APPLICATION AB/106/15/DOC
NO:

Registered: 04-AUG-15
Site Address: 55/57 High Street Arundel BN18 9AJ

Description of Works: Application for approval of details reserved by condition imposed under AB/41/12 relating to Condition No's 3, 4 and 8 - Schedule of materials, cycle storage & Drainage details

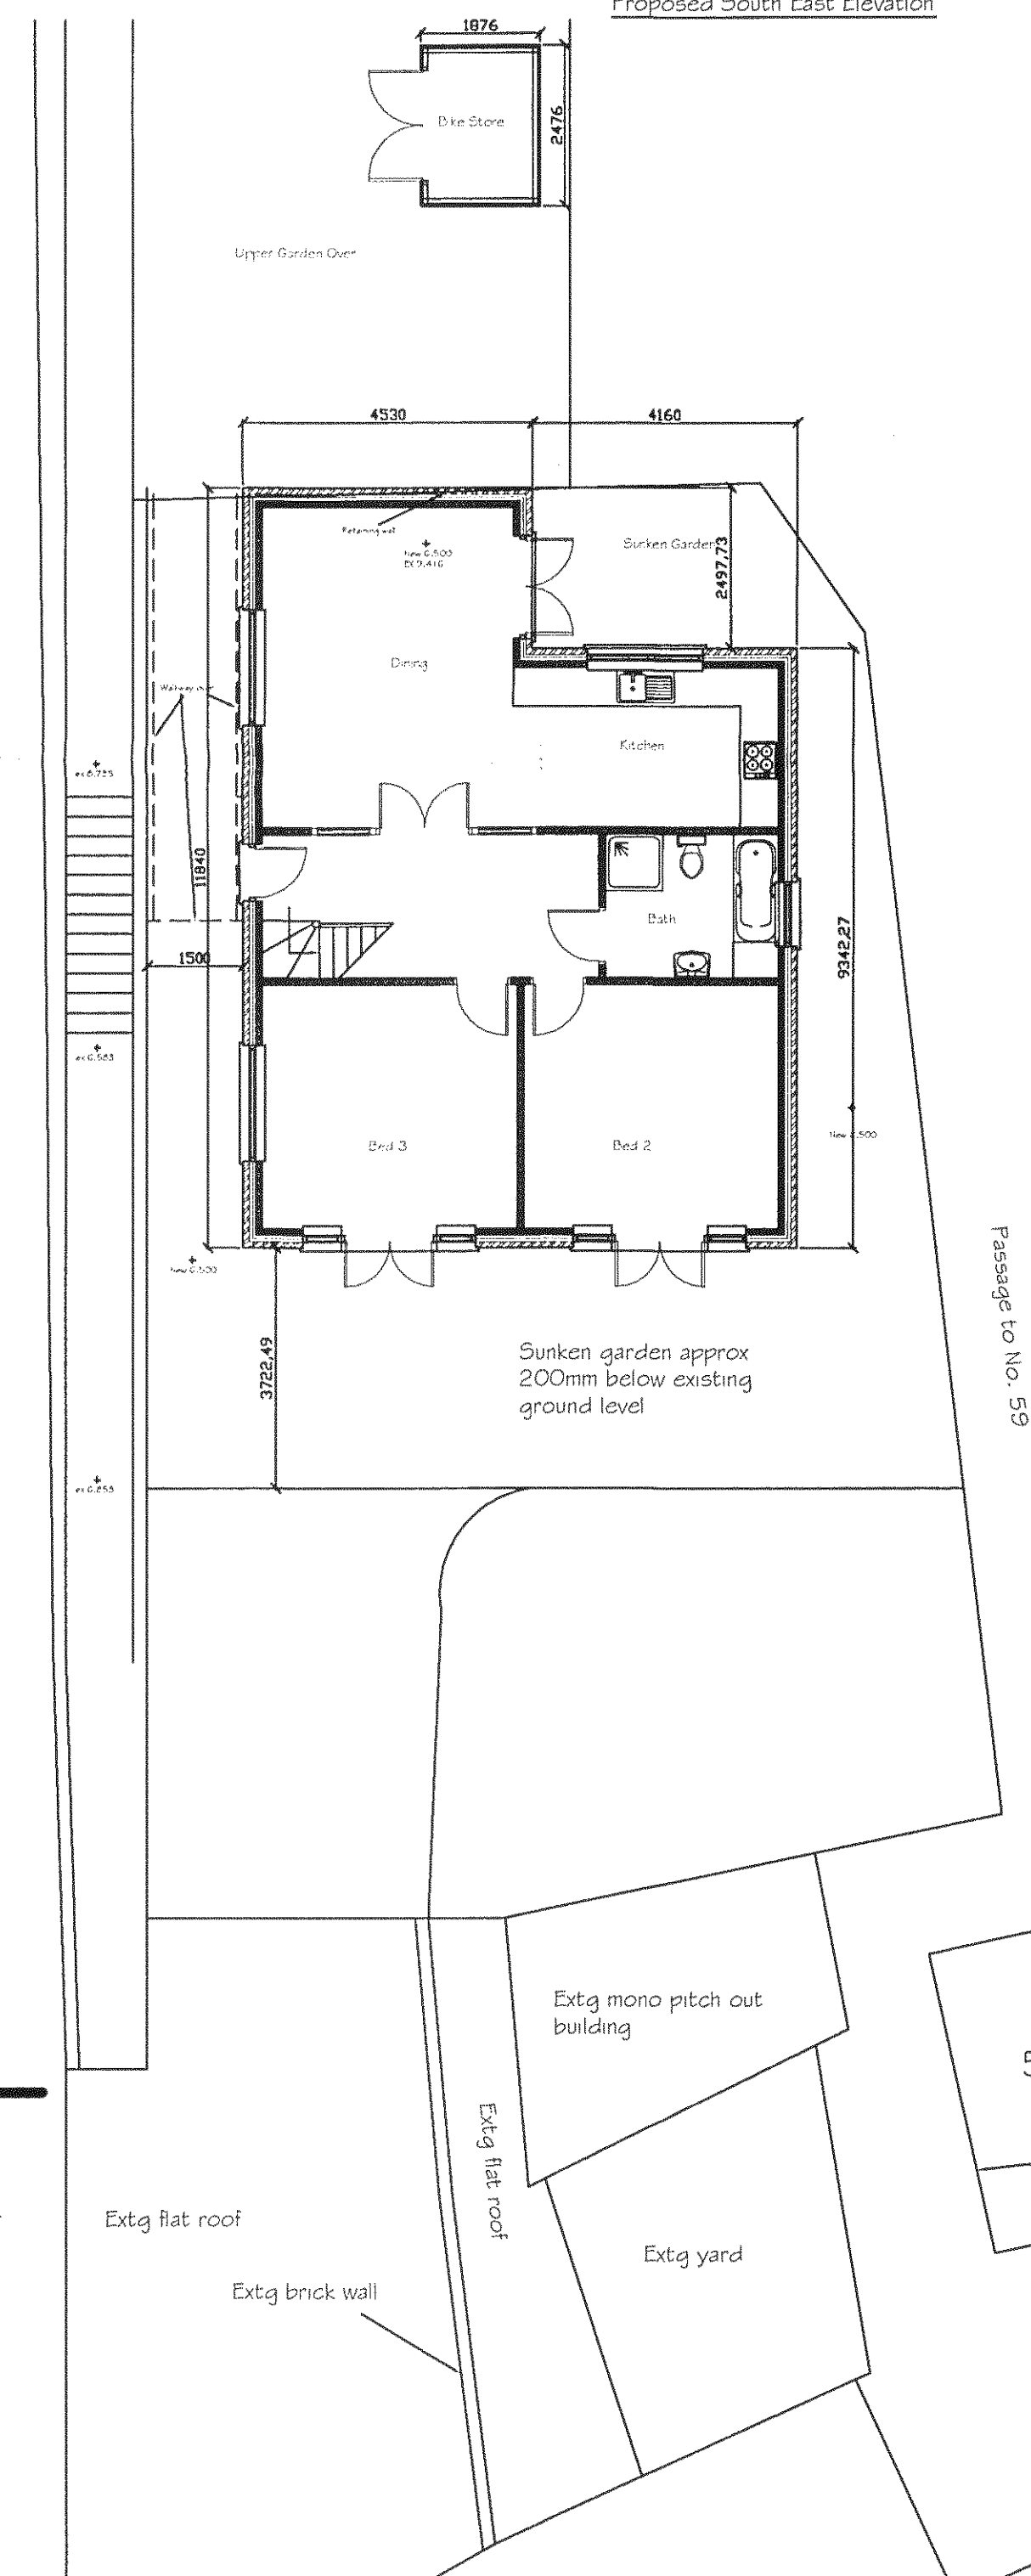
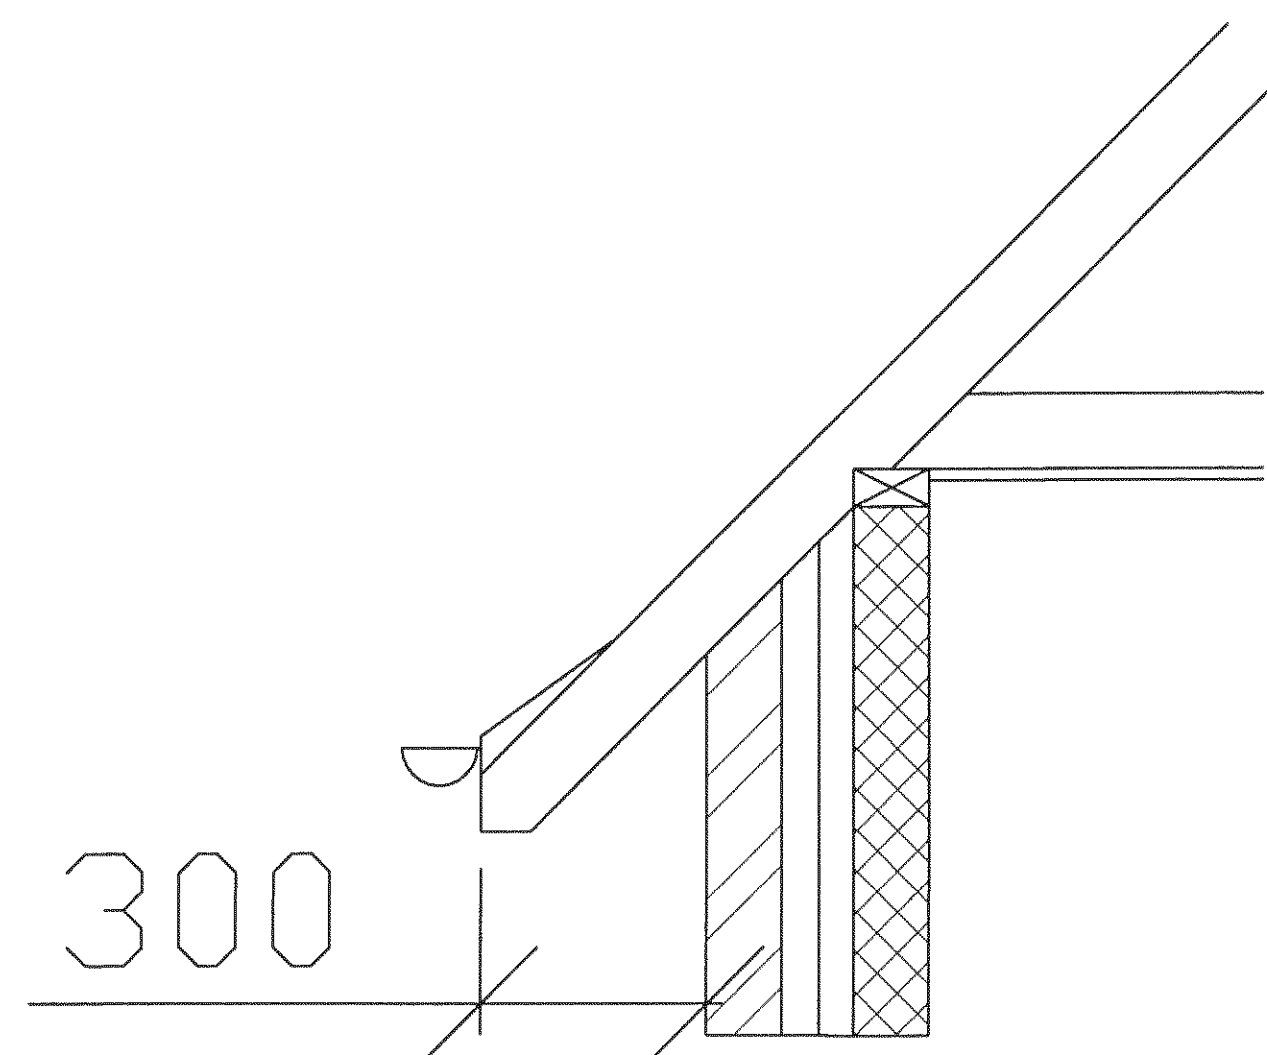
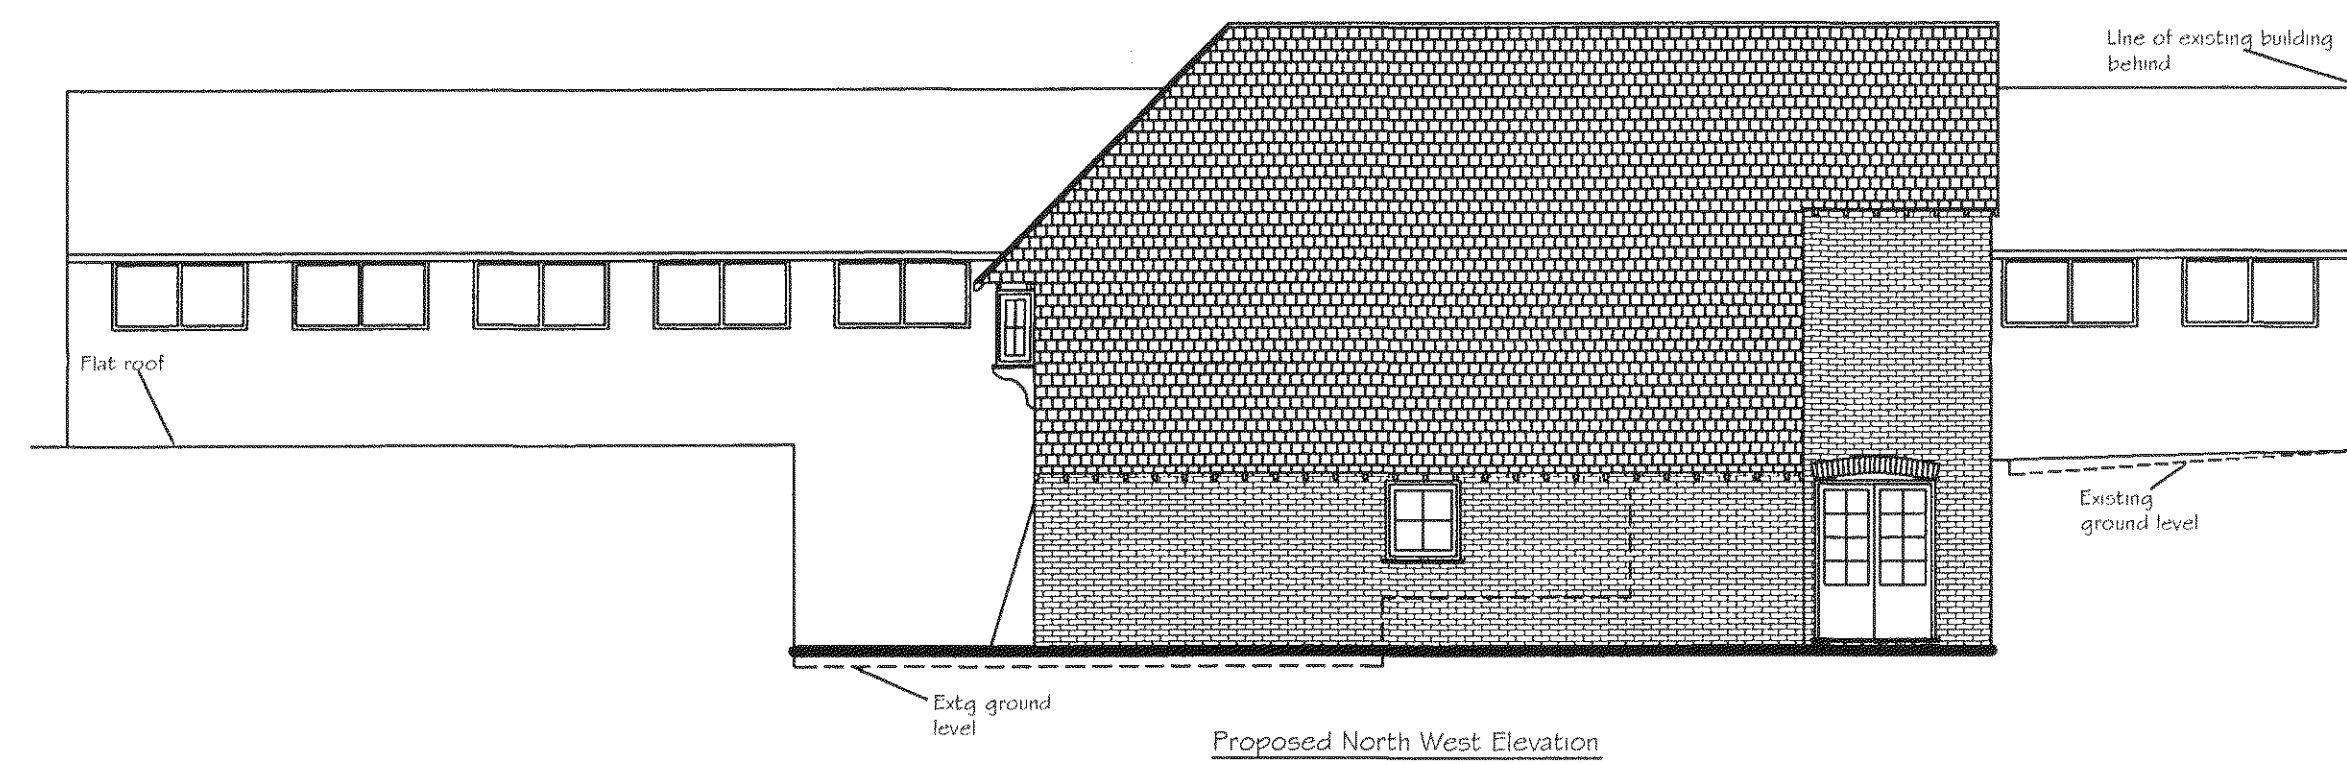
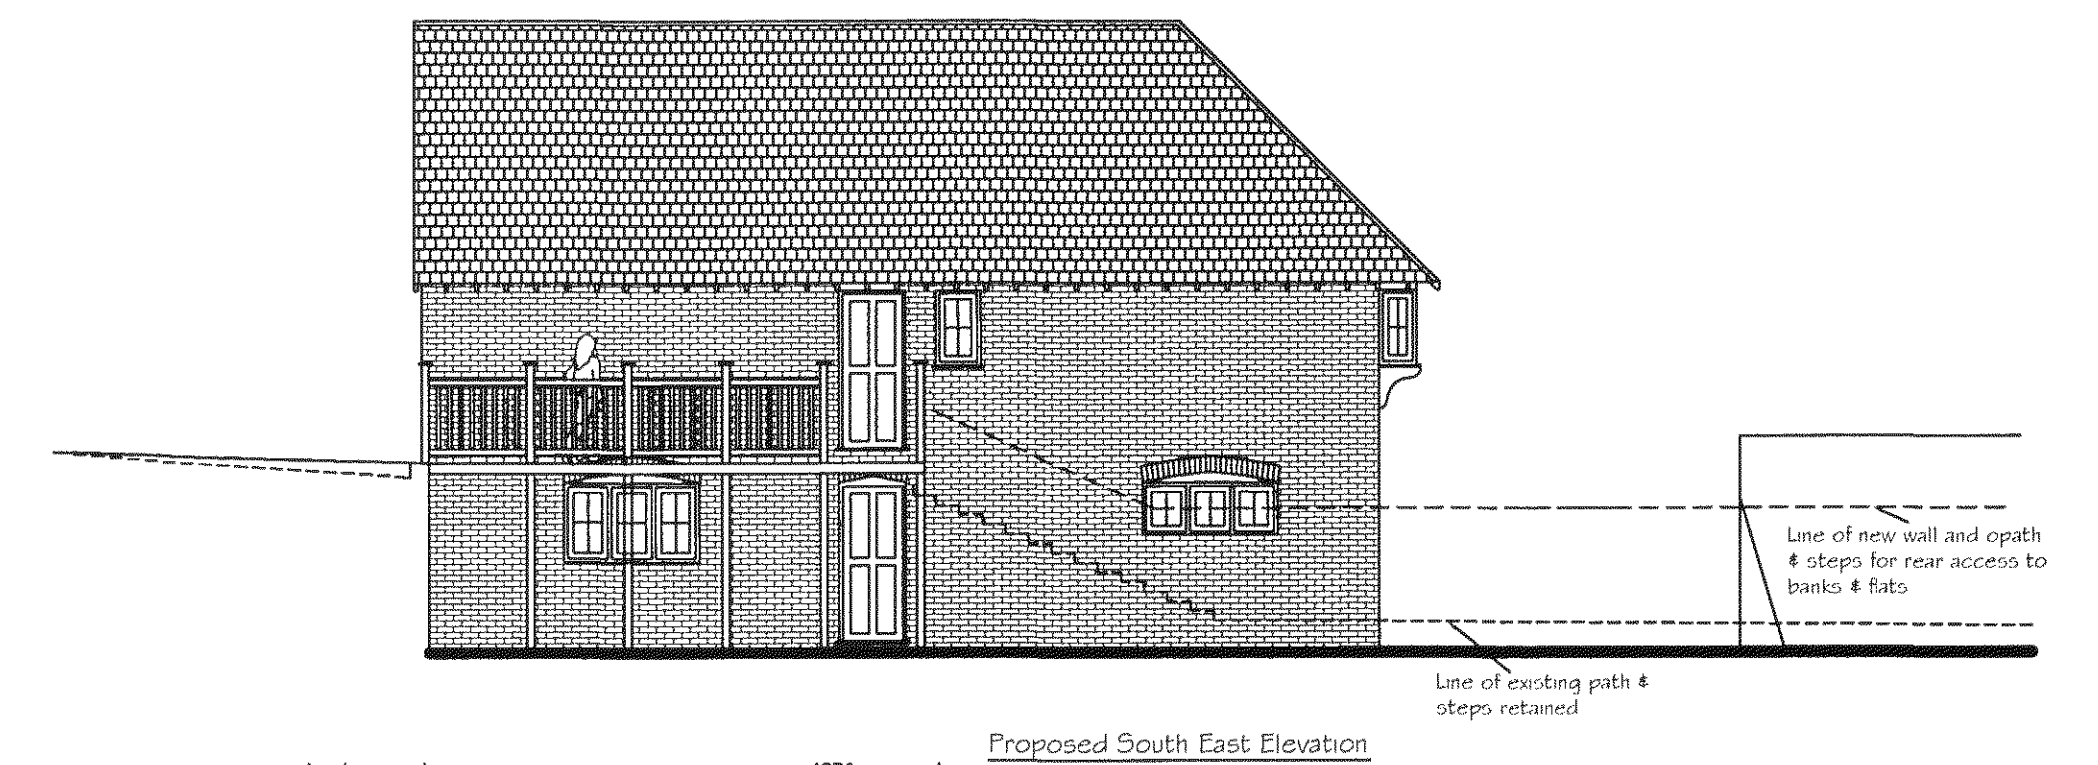
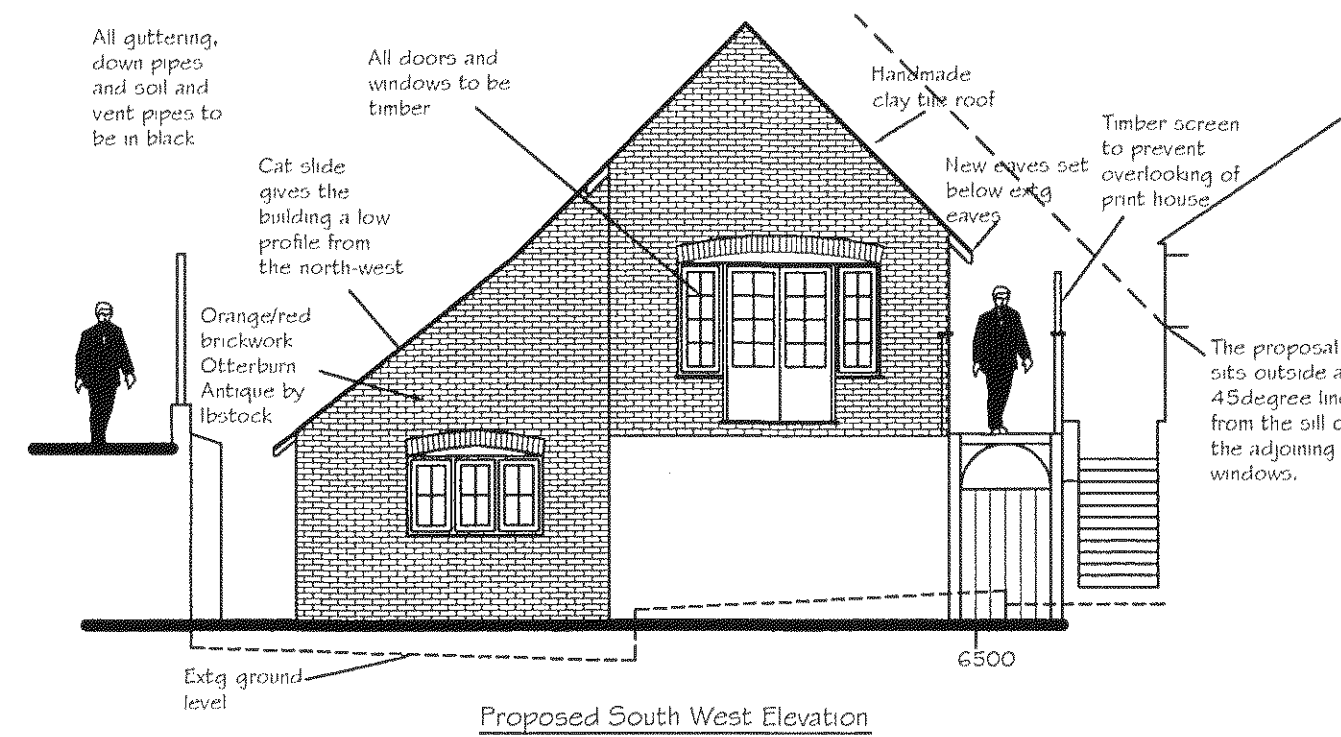
Soakaways have been investigated for surface water drainage, however site constraints mean that surface water would have to be pumped, which is not suitable. The proposed alternative is to take existing surface water drainage runs to the surface water sewer in High Street and utilise those for this development.

A plan will be required and can possibly be provided at short notice from the agent, if it is then possible to discharge the condition through the current application.

Yes that will be fine to discharge the condition
